Department of Community Services

January 23, 2023

Subject: Autumn Acres Sketch Plan – Preliminary Comments (SKP231)

ZONING MAP

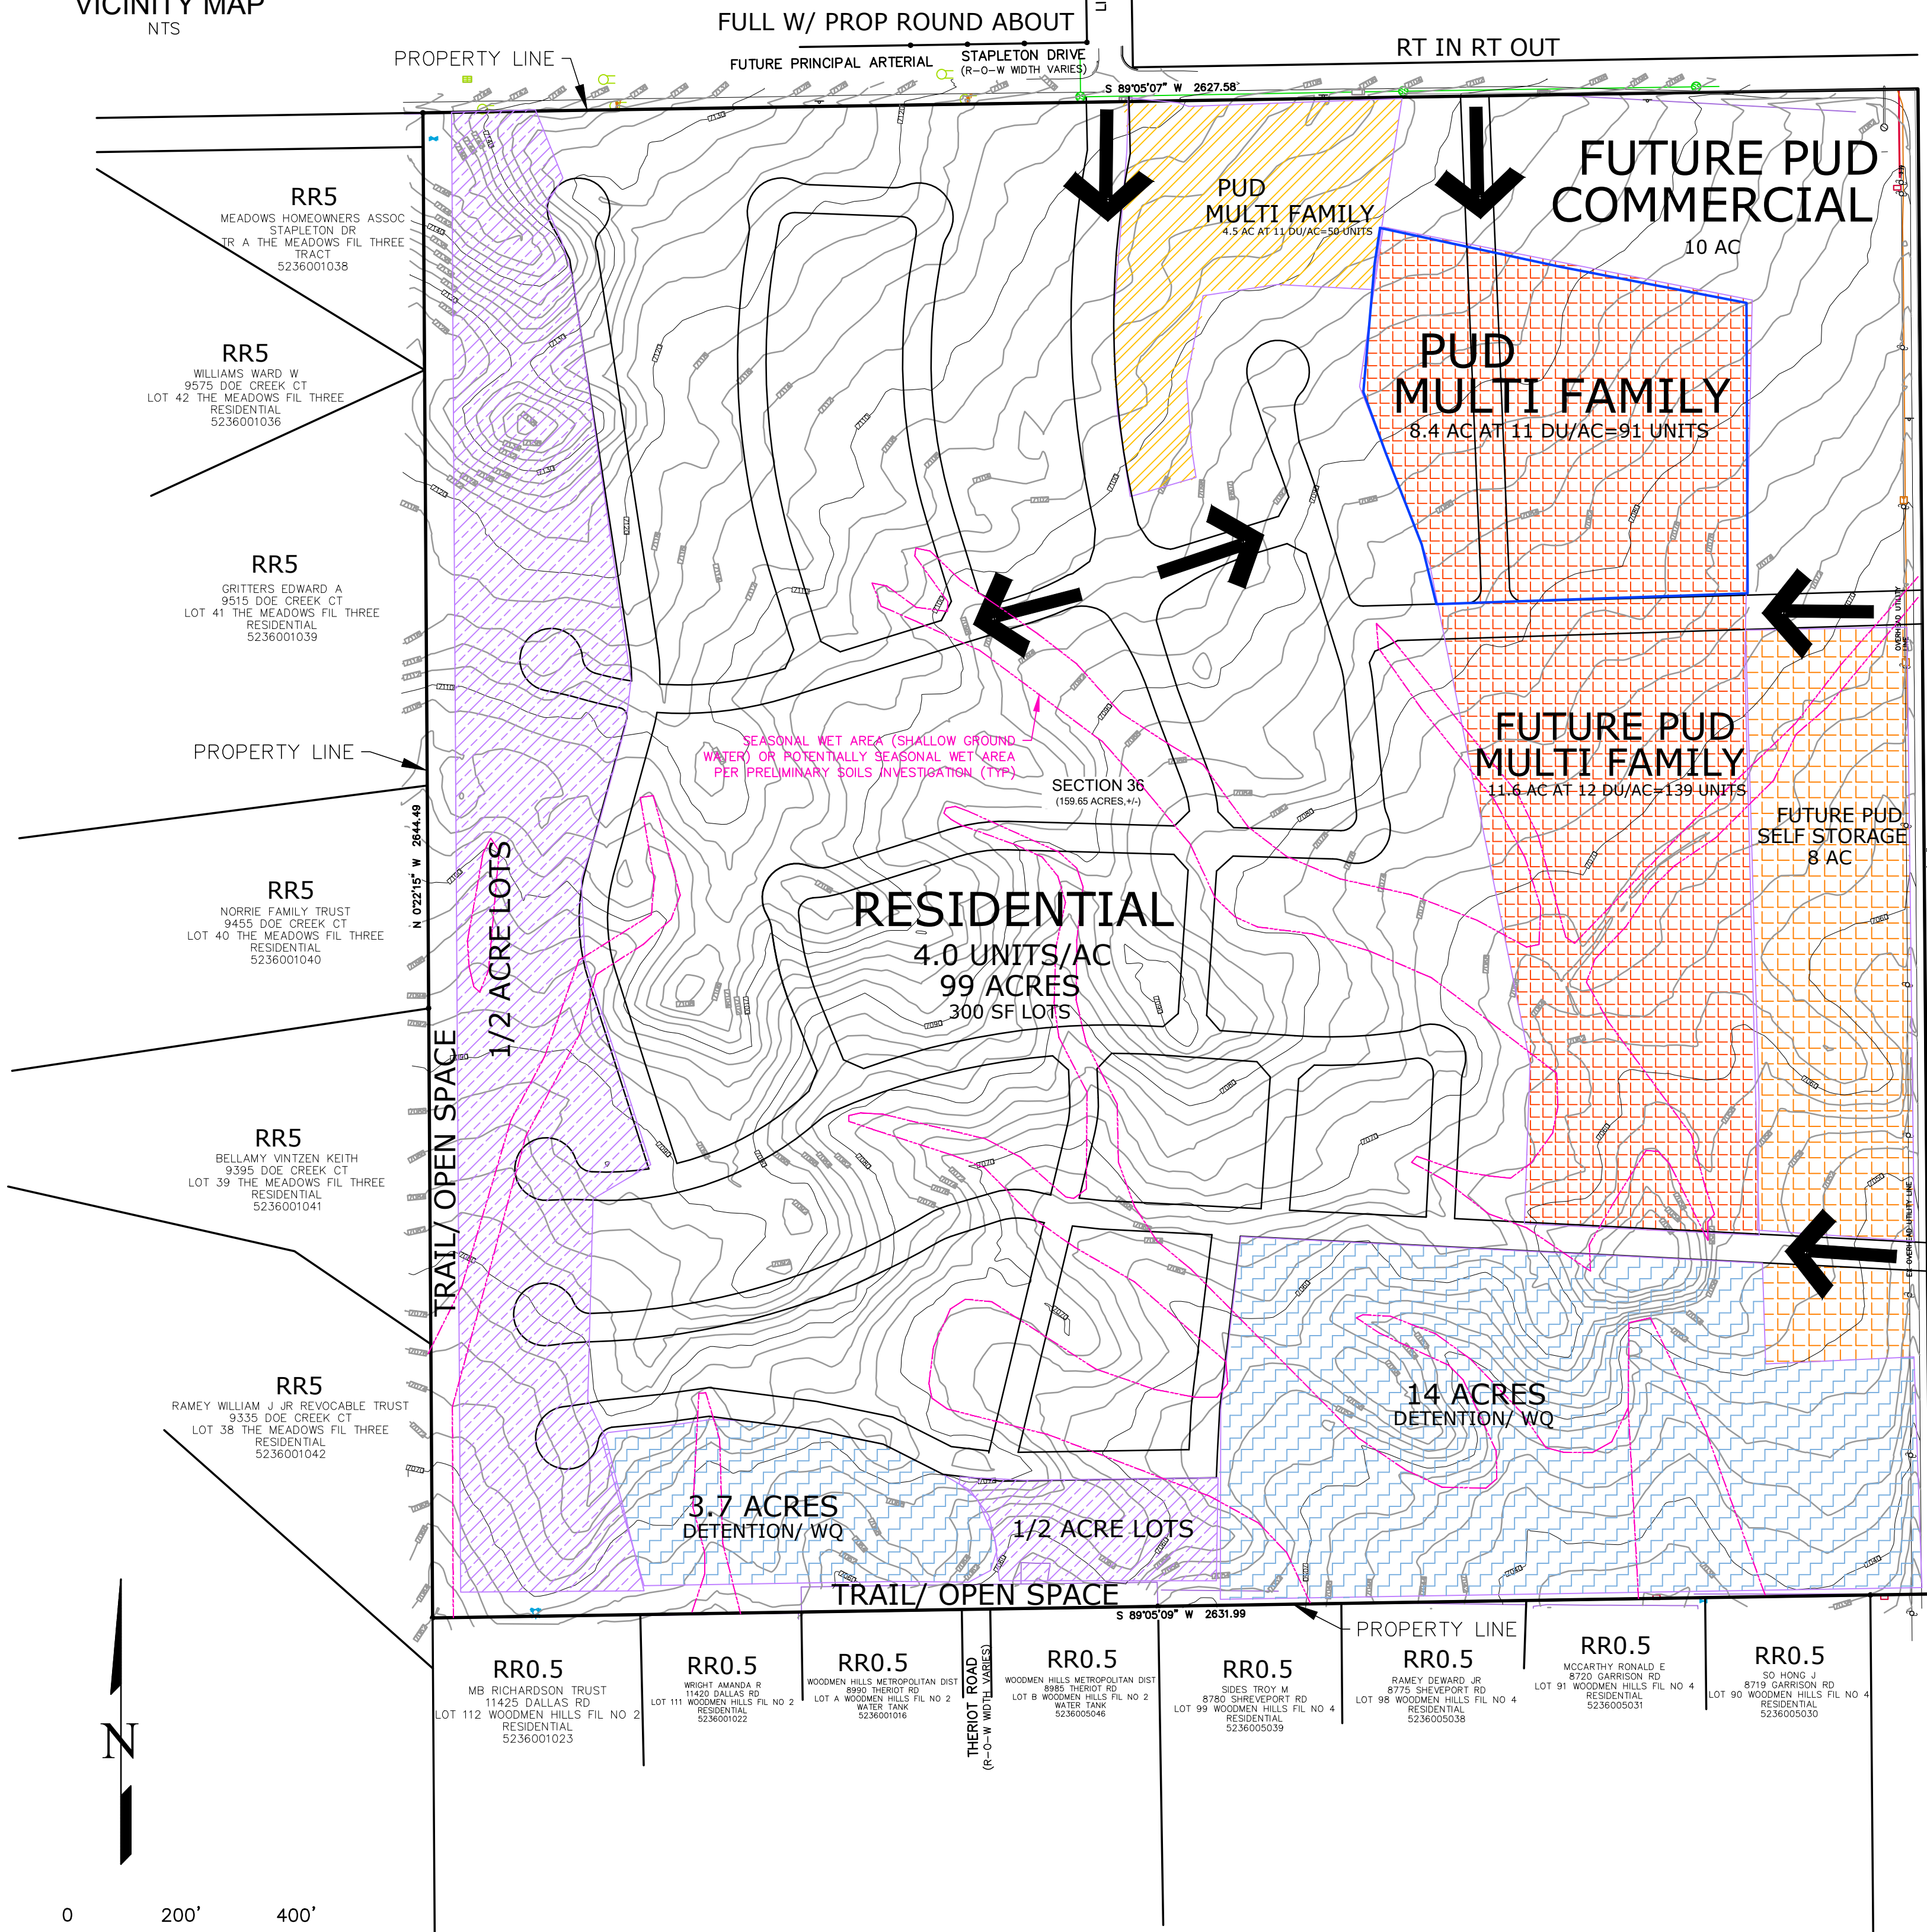
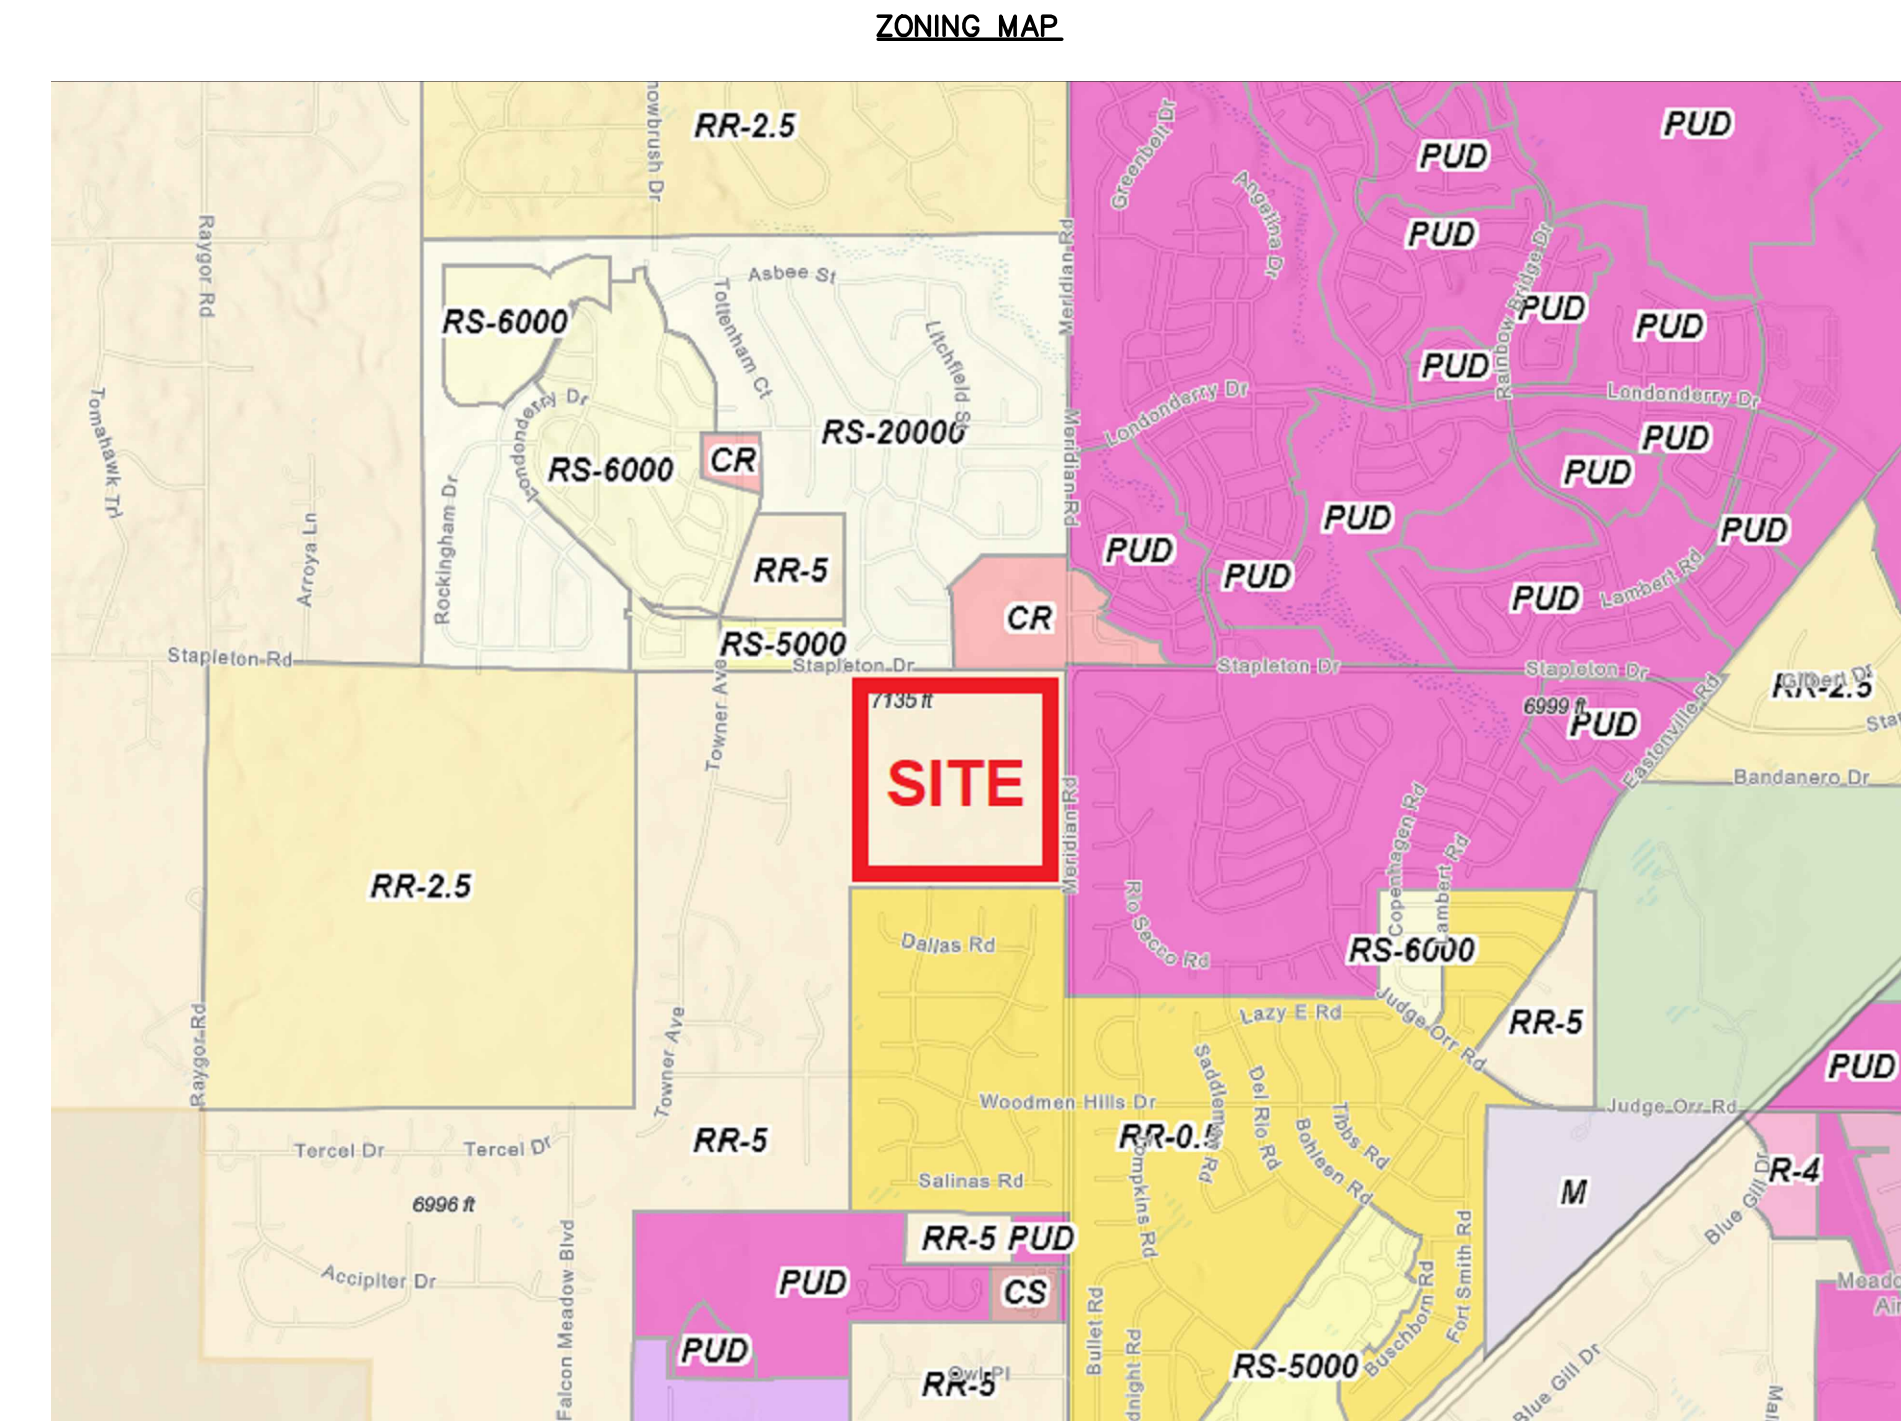
The applicant is reminded that for Planned Unit Development zoning, the minimum open space dedication is 10% of the total site area which does not include storm water infrastructure. The Land Development Code Section also outlines that dedicated open space tracts be large, usable, and contiguous. The proposed narrow tracts of open space, while serving a buffer to adjacent development, do not provide a substantially beneficial to the denser areas of the site. Additionally, for a sketch plan application, the applicant should be providing sufficient detail on proposed land use allocations, to include open space dedications. Staff understands that there are minor refinements to final open space dedications due to site design considerations but is concerned they are referenced in the letter of intent as these small areas should not be the majority of the open space dedication.

The Park Advisory Board recommends that the Planning Commission and the Board of County Commissioners include the following conditions when considering and/or approving the Autumn Acres Sketch Plan: (1) provide a detailed land use table outlining open space areas and strongly encourage the applicant to locate open space tracts in usable and convenient areas as outlined in the Land Development Code (2) fees in lieu of land dedication for regional and urban park purposes will be calculated upon review of forthcoming preliminary plans and final plats, and will be required at time of the recording of the forthcoming final plats.
